Consultee Comments for Planning Application

1/0753/2021/FUL

Address: Great Knowle Barn Pyworthy Holsworthy Devon EX22 6JY

Proposal: Creation of attached single-storey annexe, change of cladding to approved barn conversion and increase of domestic curtilage

DRAWING TITLE  
PROPOSED ANNEXE + ALTERATIONS  
Elevations

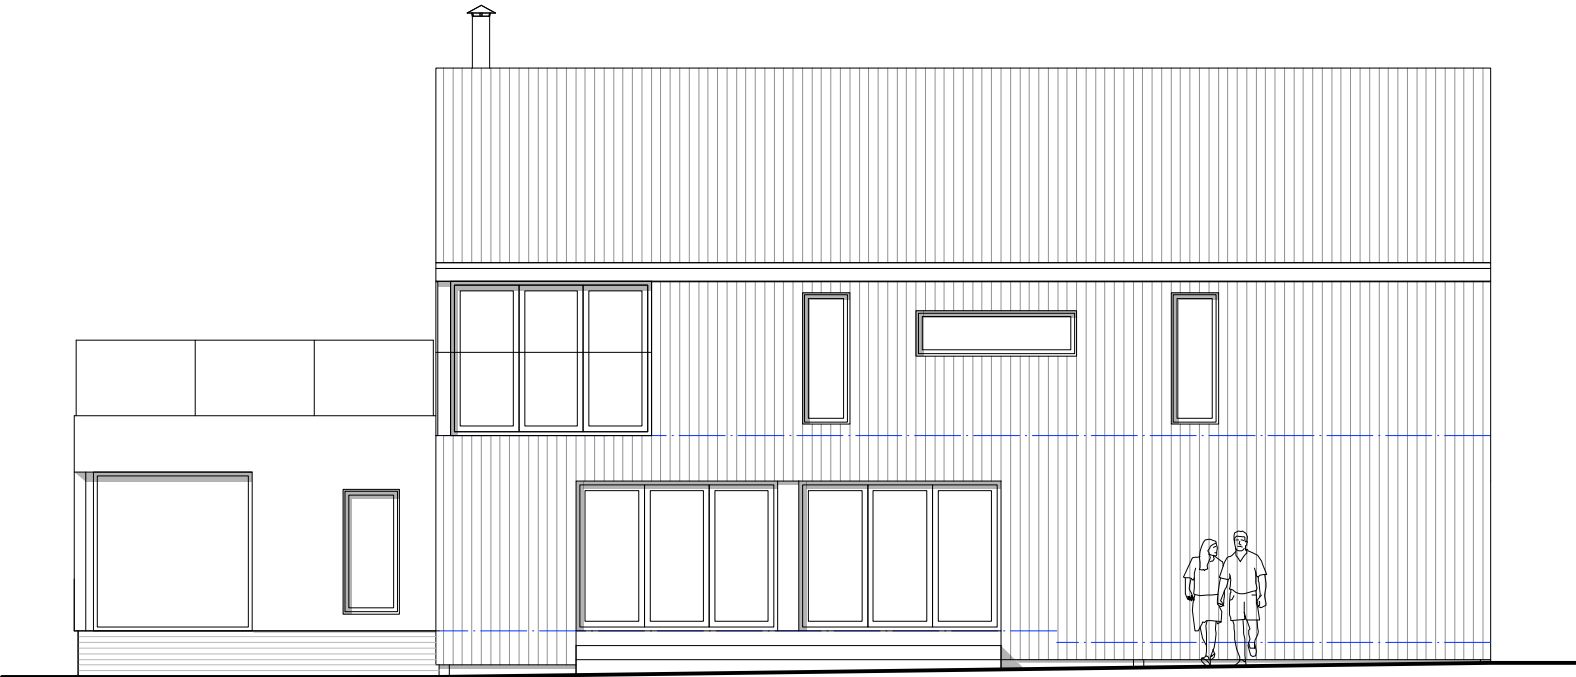
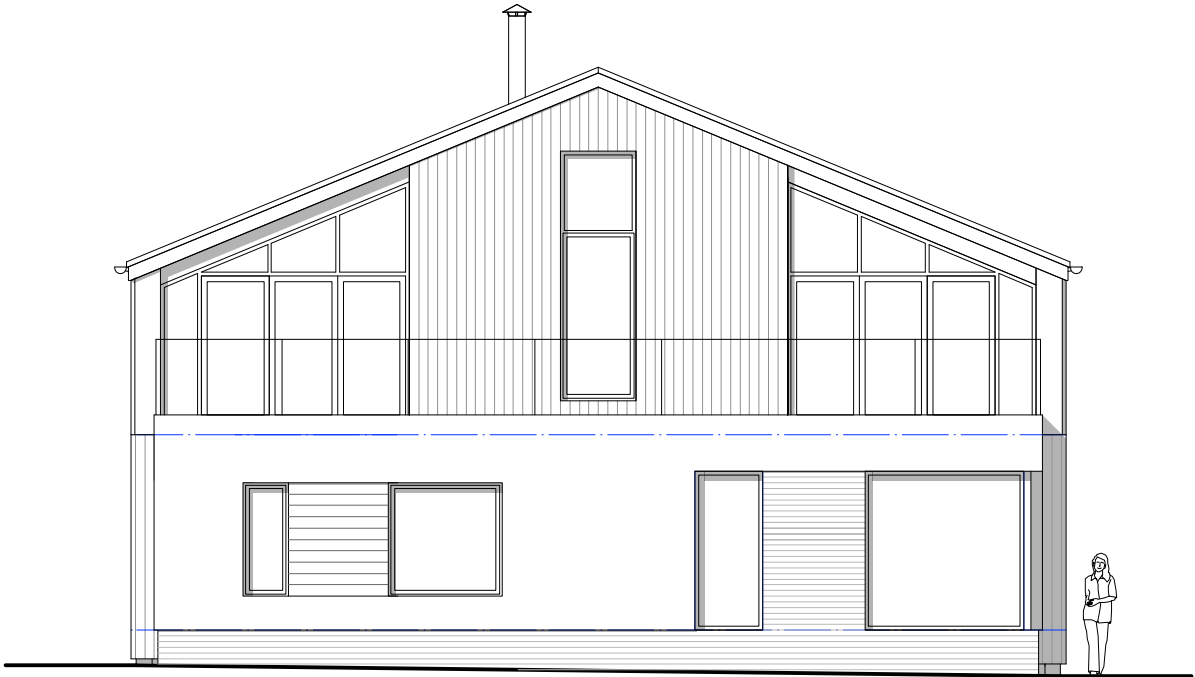
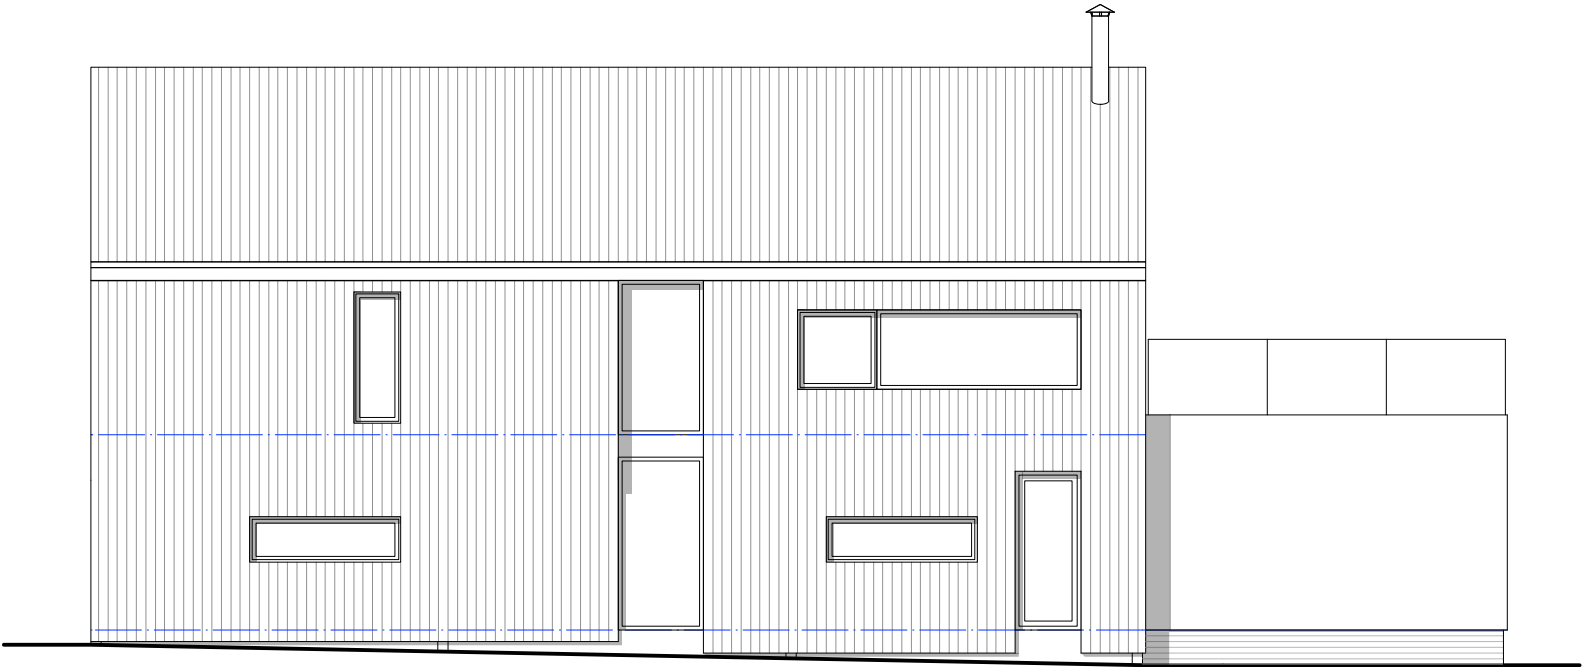
The proposed balcony on the east elevation will cause privacy issues with the property to the south. The covering letter with the application states that the view from the balcony is screened by existing outbuildings, this is not the case as the east and part of the south elevations are clearly visible from the bedroom windows and kitchen windows of property to the south.

If TDC approve this application then they must attach tree preservation orders and conditions to the existing hedgerow and also a condition to provide adequate screening on the south elevation of the balcony.
